ASSESSMENT REPORT

Mixed Use Development – 1 Lawson Square, Redfern SSD 5249 MOD 5

The application has been lodged by Ethos Urban on behalf of Lawson Square Pty Ltd pursuant to section 4.55(1A) of the *Environmental Planning and Assessment Act 1979* (EP&A Act). It seeks approval to add roof top terraces to the eastern tower to be used in association with two approved top floor apartments.

DRAWING:
ROOF PLAN

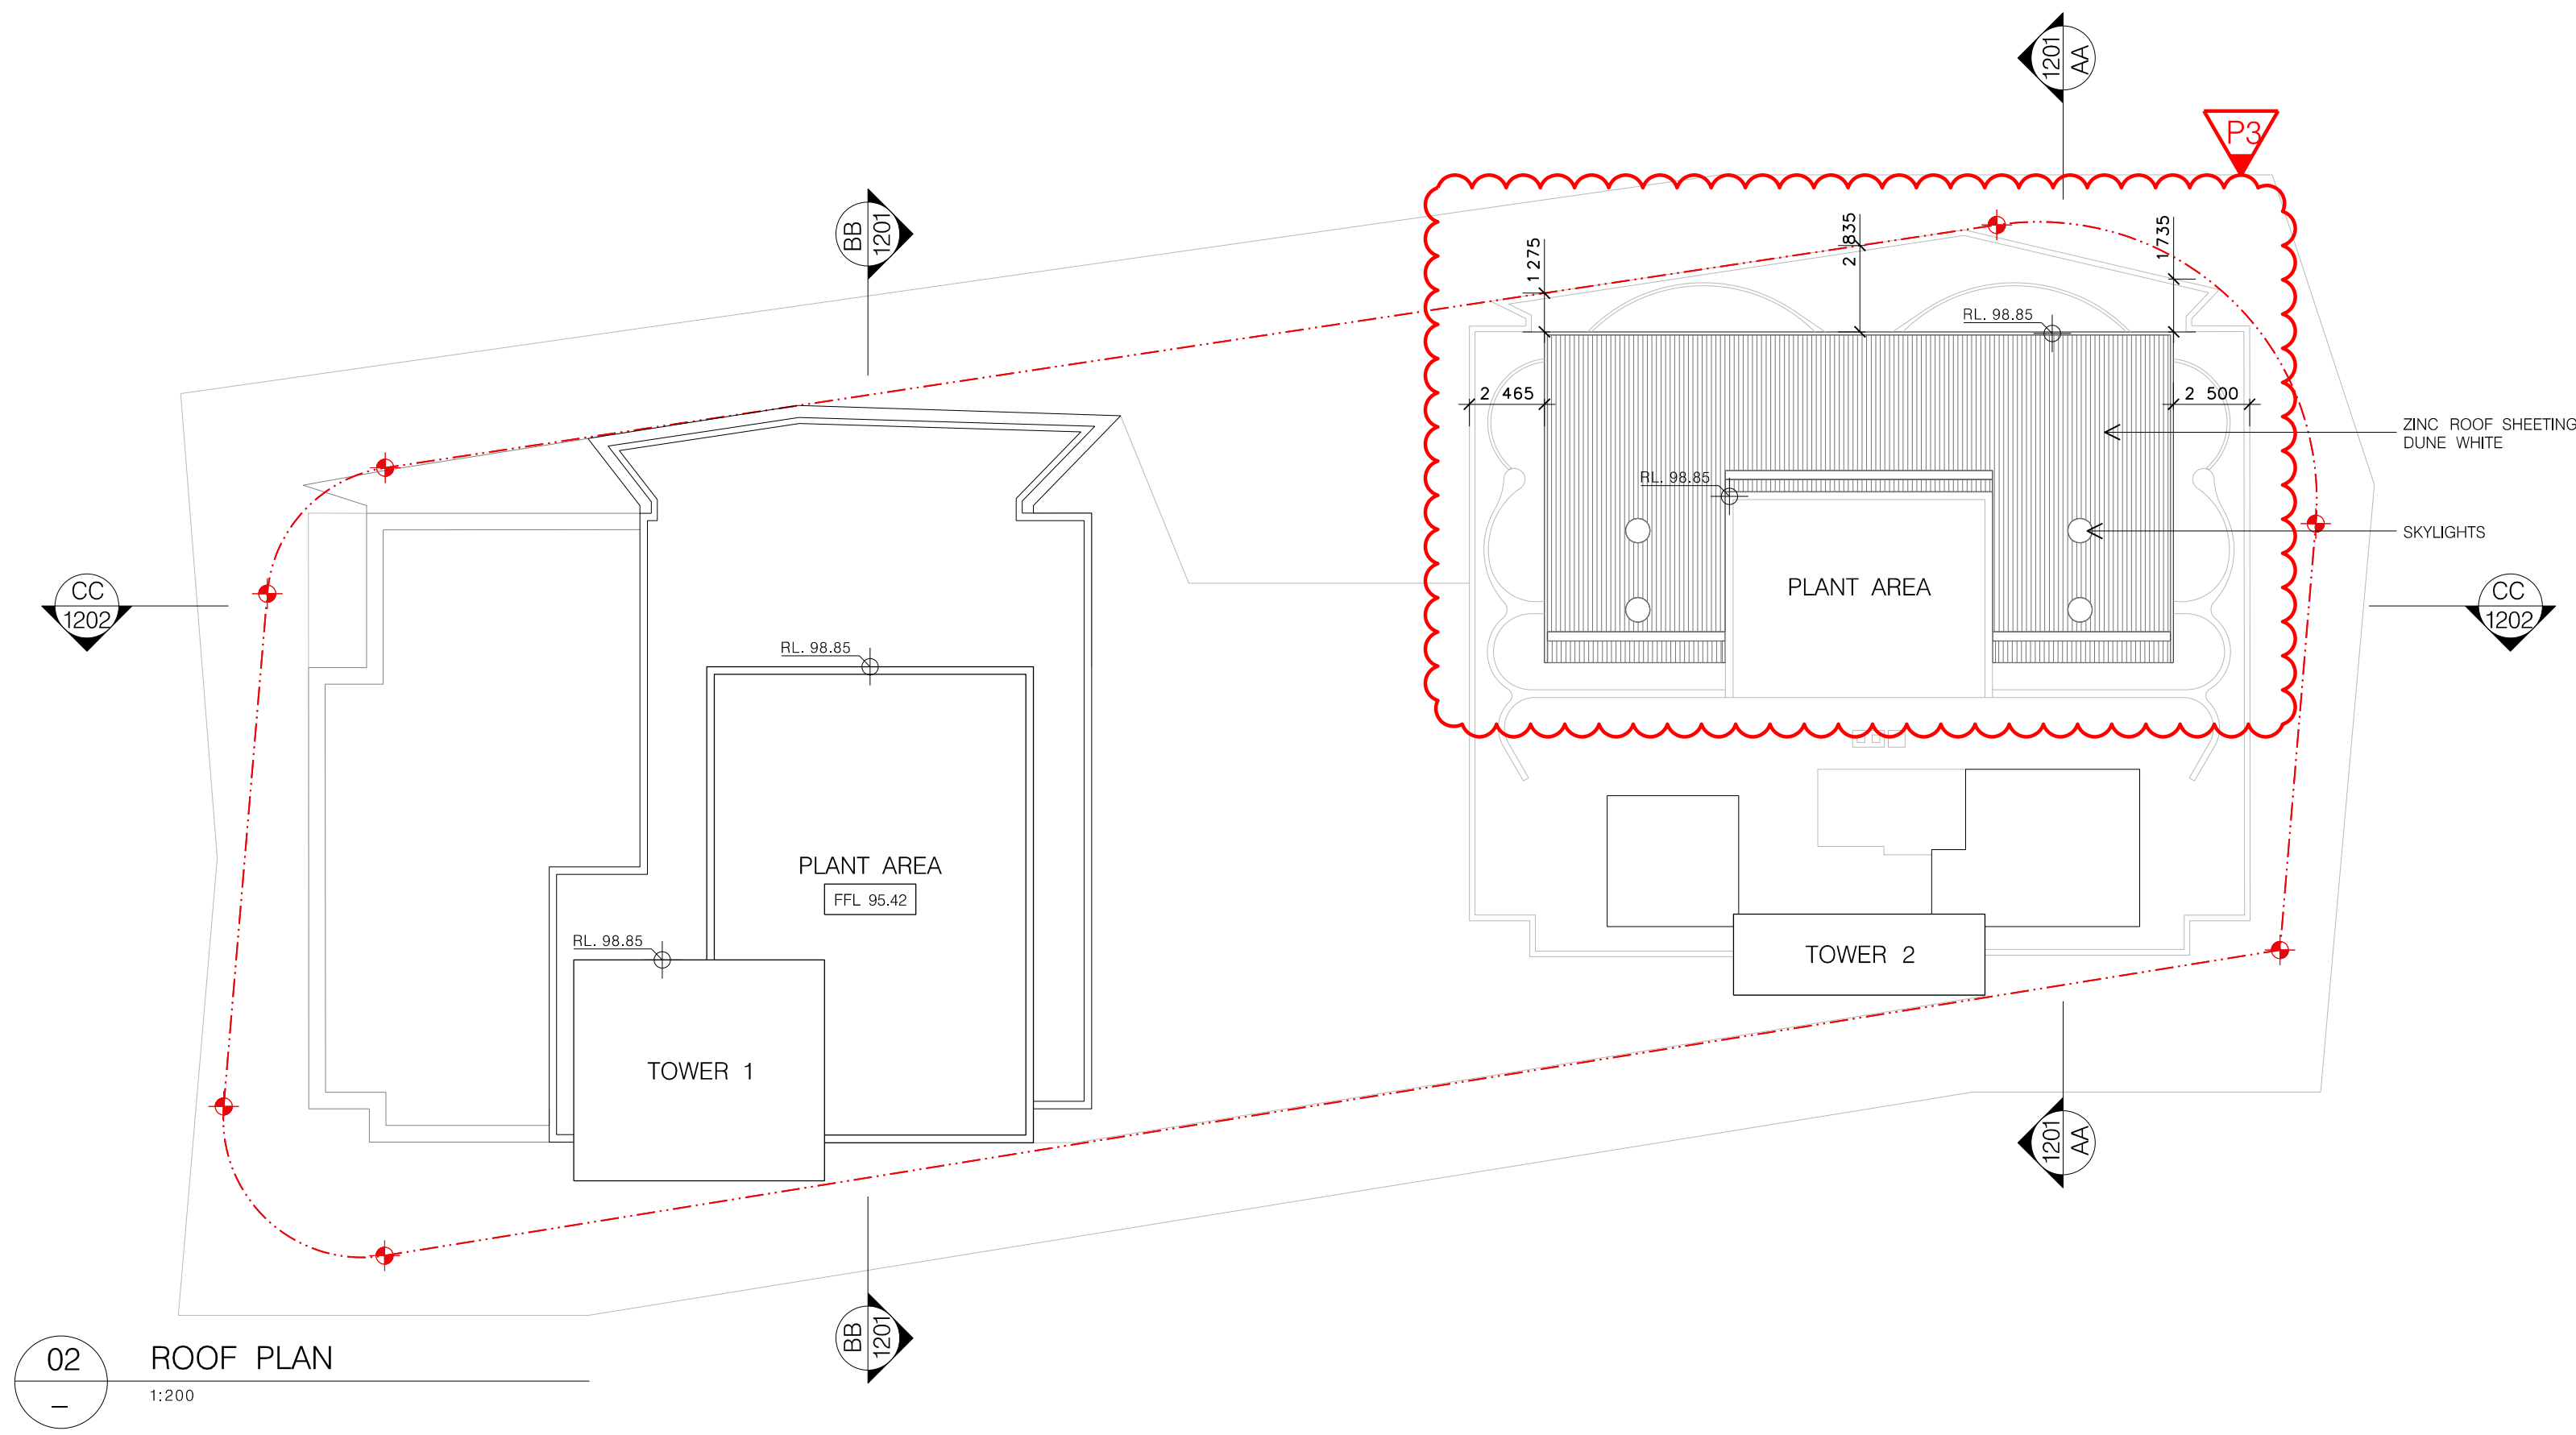
Visual Impacts	• The proposed changes to the roof level would result in a minor increase to the height and scale of the building when viewed from a distance. • The roof canopy would be the most visible aspect. However, it would be a lightweight structure, with a maximum height consistent with the plant rooms, generally open in appearance and setback on average 2.4 m from the building edge. • Apart from the roof canopy, the curvilinear walls around the bathrooms and spas would be visible from some vantage points, predominantly from the east. However the proposed walls would also be setback from the building edge, would be lower in height than the roof canopy and plant rooms and would be constructed of materials to complement the existing building. • The Department considers that as the proposed structures would be set back from the building edge they would not be dominant visual elements, would not detract from the design excellence qualities of the	No additional comments or amendments necessary

approved building, and would not have any impact for the overall character of the area. - The proposed changes would also improve the architectural quality of the roof level, obscuring views of the approved plantrooms with new curvilinear walls, an architectural roof form and plantings. - The Department therefore considers the proposed structures would make a positive contribution to appearance of the building.	
<i>Shadowing</i>	- The Applicant submitted shadow diagrams to demonstrate the shadowing effects of the proposed modification. - Shadows cast from the proposed roof terrace structures would fall predominantly on to the southern part of the roof of the approved development and for the majority of the day would not affect any adjoining development. - In the mid-late afternoon at midwinter the proposal would result in a nominal amount of additional shadows cast to the west of the site. - Council recommended investigating whether a reduced room form would reduce or eliminate the increased overshadowing effects. - The Department has considered the shadows and notes the area of additional shadow would not be perceptible in the context of shadowing from the approved building and would predominantly be within areas already in shadow from other surrounding buildings. - The shadowing impacts are therefore considered to be negligible and of no consequence, and no amendments to the roof form are required.	No additional comments or amendments necessary
